Mr J Dowling
Additions
47a Felpham Way
Bognor Regis
West Sussex
PO22 8PT

Application for Householder Planning Permission

Development Rebuild garage and rear extension
Location Bilsham House Bilsham Road Yapton Arundel

Existing Rear Elevation

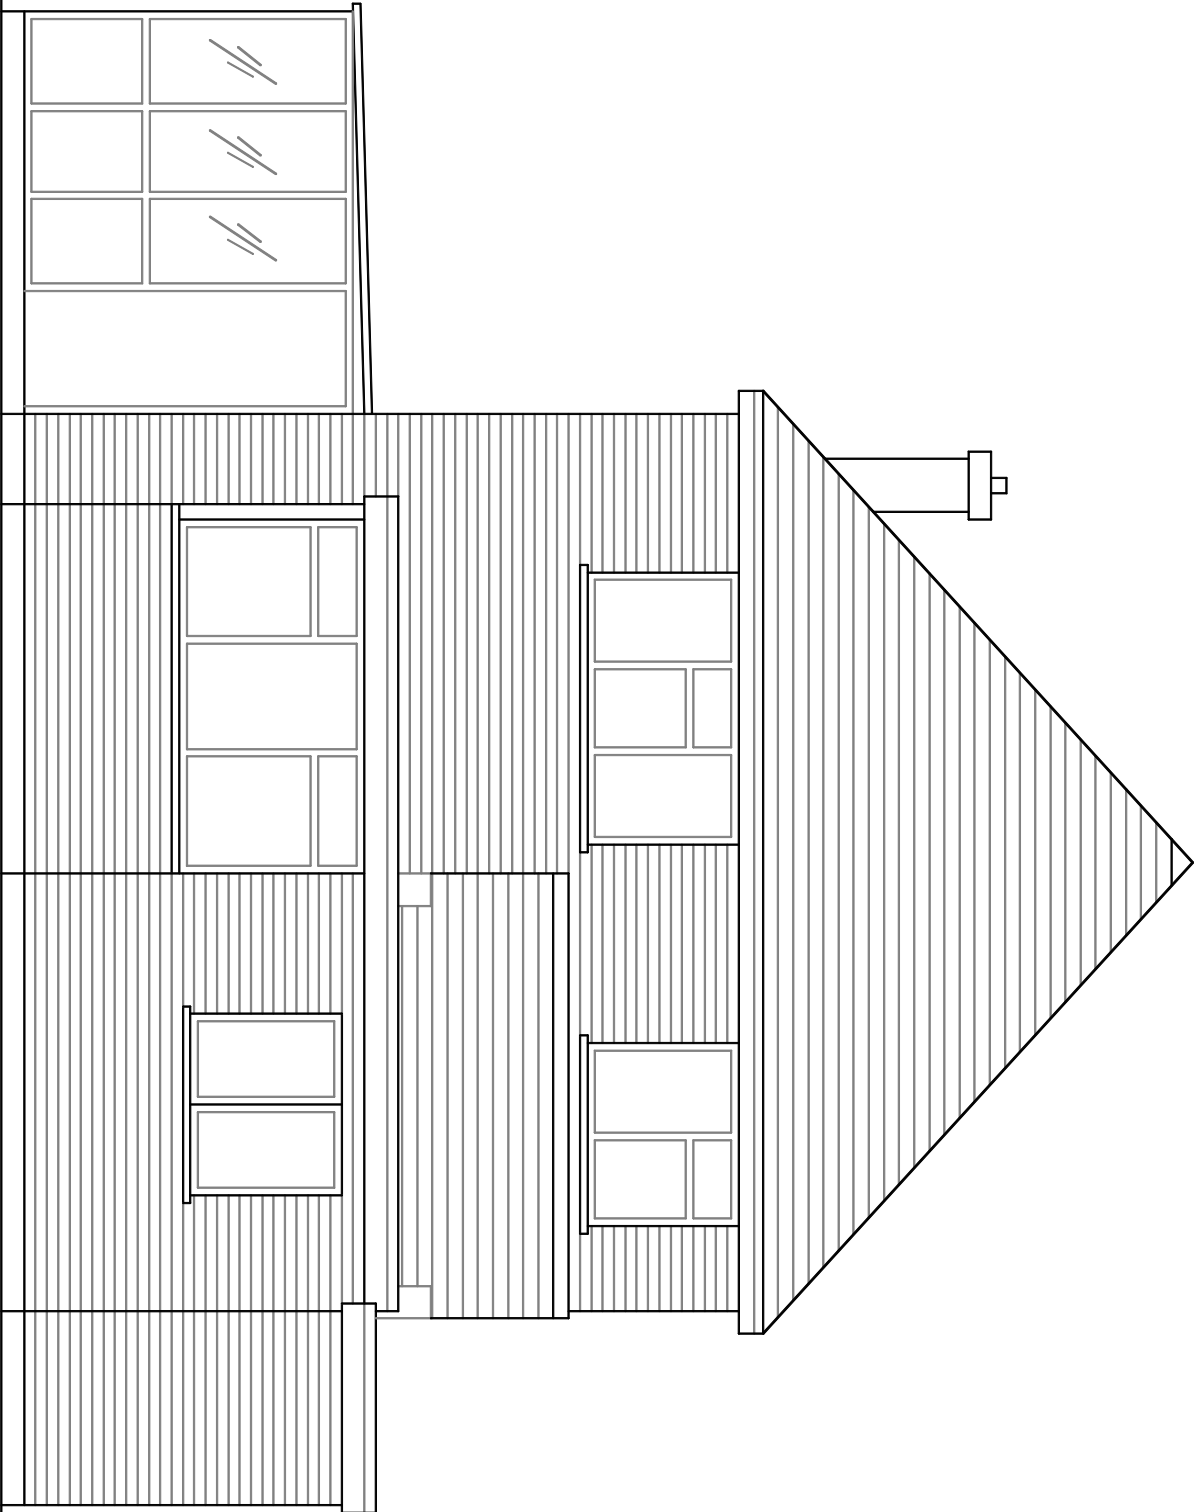
The existing rear elevation does not accord with the existing rear floor plan. Please amend accordingly.
